RE: 2609 Corianda Court NW
Grading and Drainage Plan
Stamp Date: 7/31/17
Hydrology File: G13D026

RE: 2609 Corianda Court NW
Grading and Drainage Plan
Stamp Date: 7/11/17
Hydrology File: G13D026

Based upon the information provided in your submittal received 7/12/2017, the Grading Plan **is not** approved for Building Permit. The following comments need to be addressed for approval of the above referenced project:

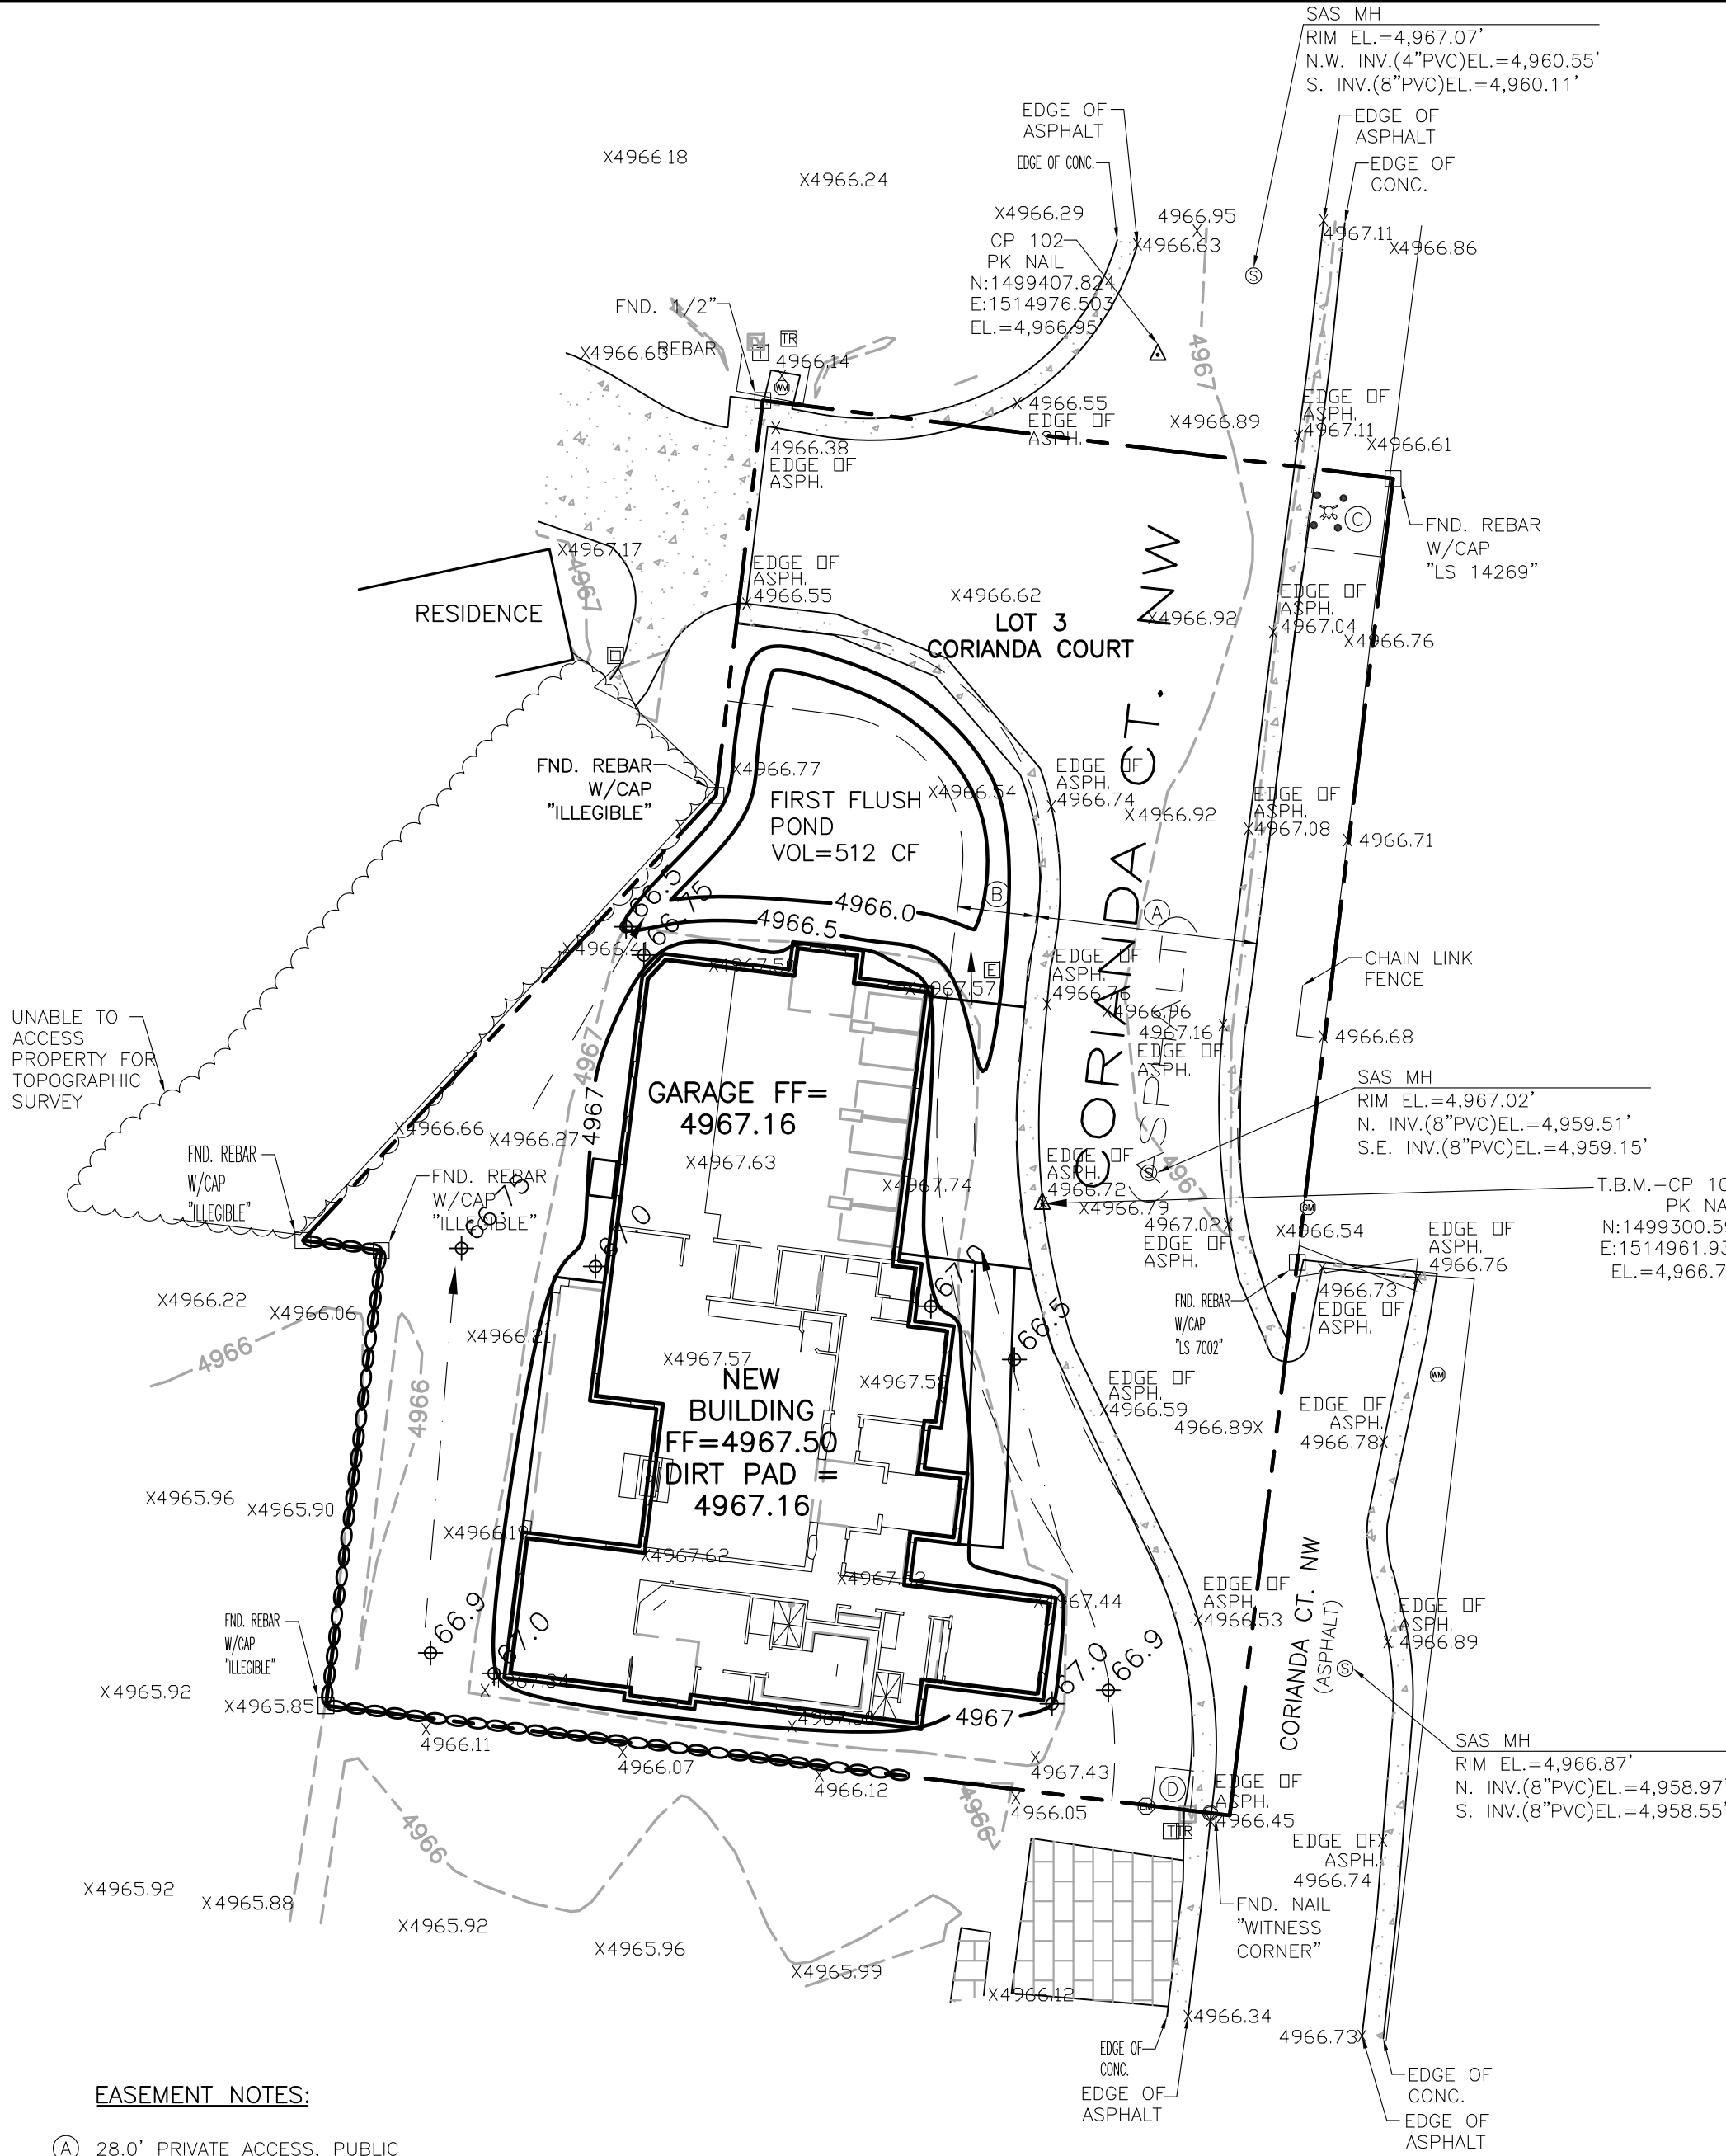
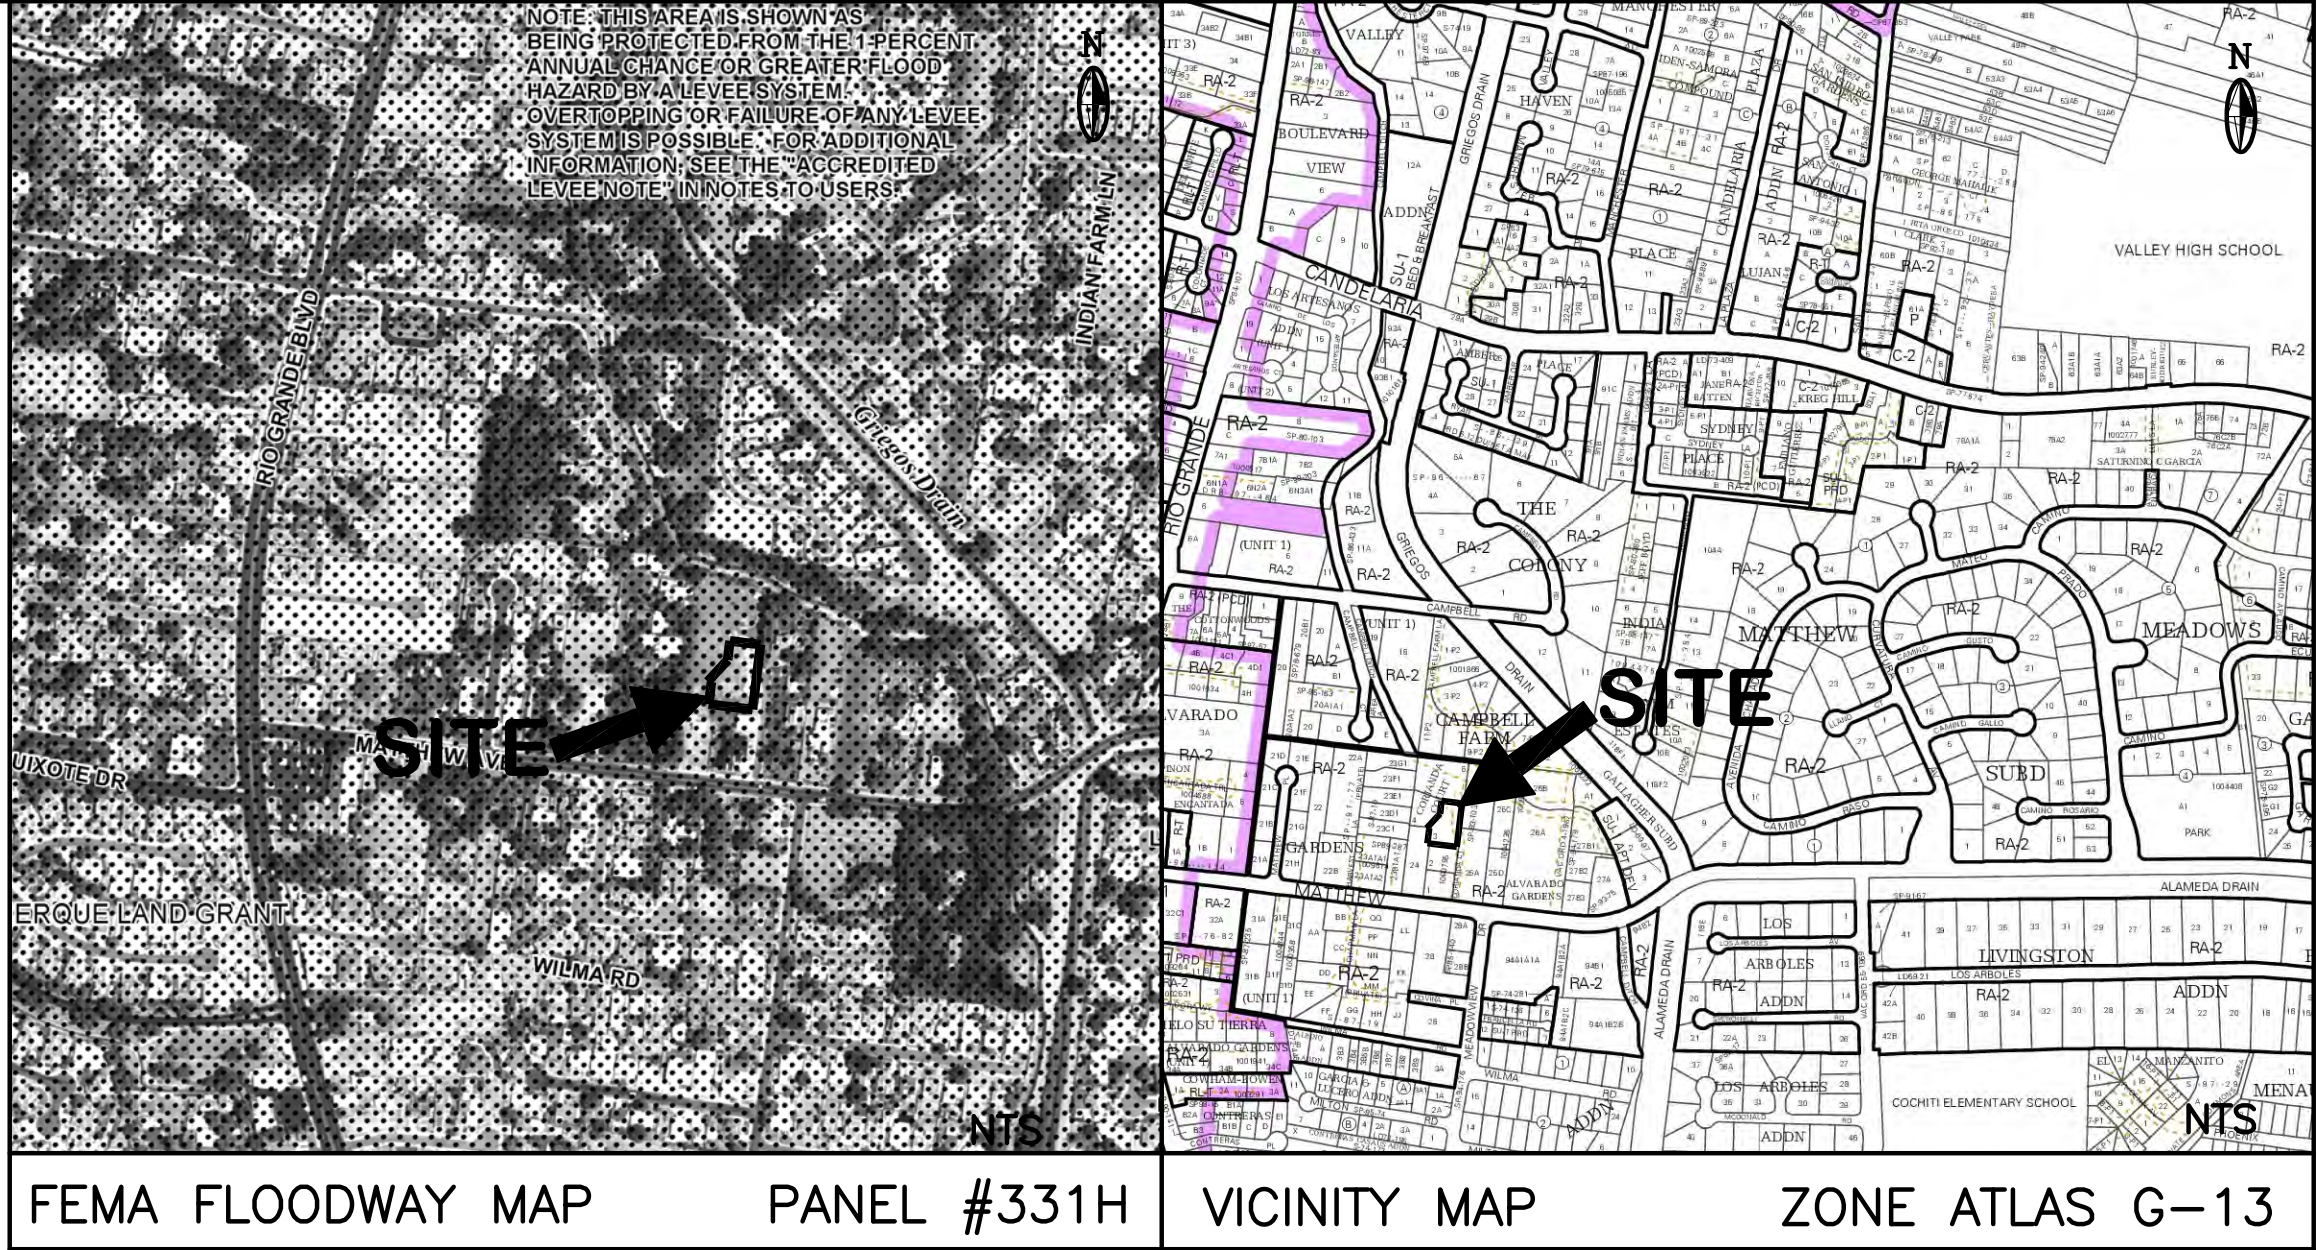
1. Please provide the flood plain note with effective date. This property is in Zone "X" protected by levee. **PROVIDED.**
2. The approved Grading and Drainage for the subdivision had the lots in a "flat grading scheme". The Zone X Protected by Levee / Flat Scheme is as follows:

- a. The floor elevation of the house must be a minimum of 1' above the highest existing adjacent elevation. **PROVIDED.**
 - b. A retention pond is required. Required Volume = 3.67" x proposed impervious area / (12in/ft). Show location and elevation of pond on plan. Show calculation of both required and actual volume. **PROVIDED.**

- c. The street must be allowed to drain into the lot. **PROVIDED.**
3. Please provide either a CMU block garden wall or a berm along the property lines it ensure that the drainage stay within the lot. **PROVIDED.**

4. As a reminder, please do not forget to create a pond across the private drive at the northeast portion of the property. **PROVIDED.**
